29th August 2014 Miss. S. Saxby & Mrs. Tak
71 Greenfields.

Karl Roberts.
Asst. Director of Planning
& Economic Regeneration.
Arun District Council.
Maultravers Road
Littlehampton, West Sussex

Re:- Planning Application. LU/223/14/PL
land to the North of 52-67 Greenfields

DRAWING NO. J48.22/02
Scale: 1:200 at A3
Added to by: NL
03/02/2014

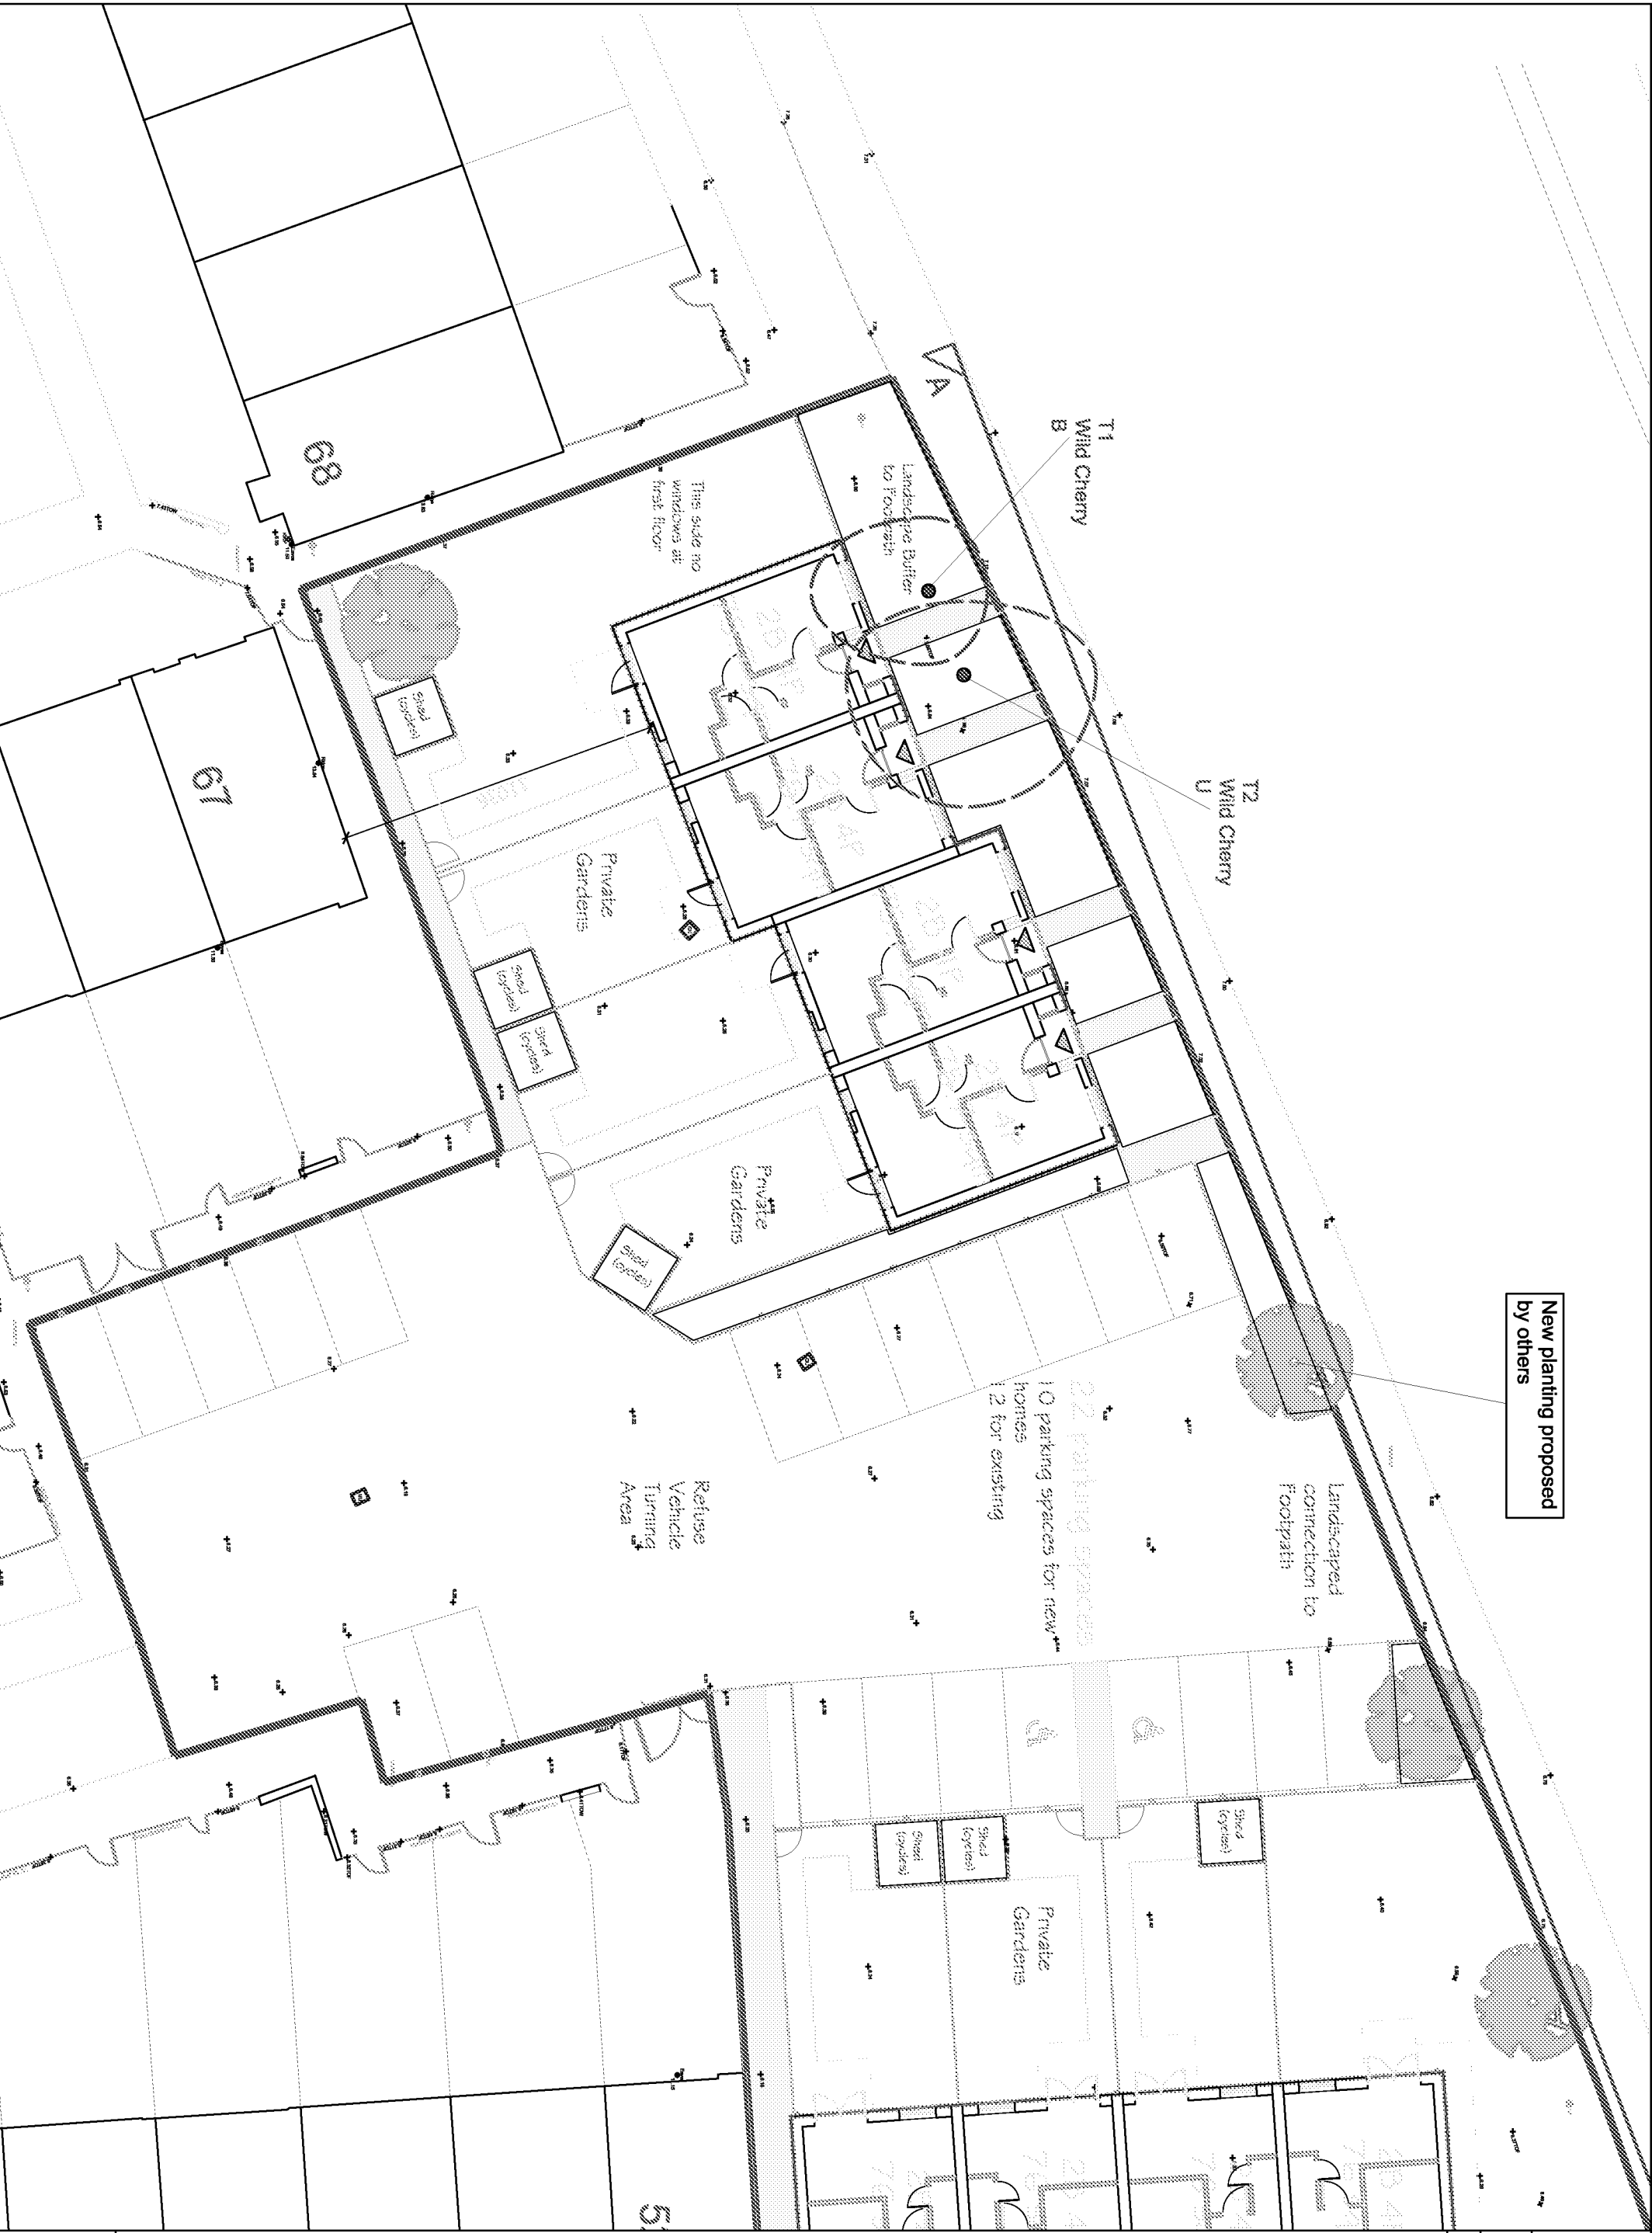
1. As much as new parking spaces are being created, it seems that they are really being moved and decreased. We have enclosed a recent photo of the

car park we use, taken at night. As you can see it is a busy and well used parking area. Taking this away will mean we will all be forced to park further away from our homes. As we both have back problems this will become a worse issue for us when having to unload shopping etc from our vehicles.

2. With regards to some of the 'new' parking spaces, showing on the map ^{that} I have enclosed, the plans are misleading & wrong. This is because the total amount stated are not new. There are already spaces there of which many are already used on a regular basis by people living in 'Elsping Mead'.

3. At present we leave our

rubbish out for collection at the end of our block of houses in the corner of the car park. This will no longer be the case if the plans go ahead. Looking at the said plans it seems like we are going to have today's journey with our rubbish which is three times that which we do now. This will also have an impact on our back problems.
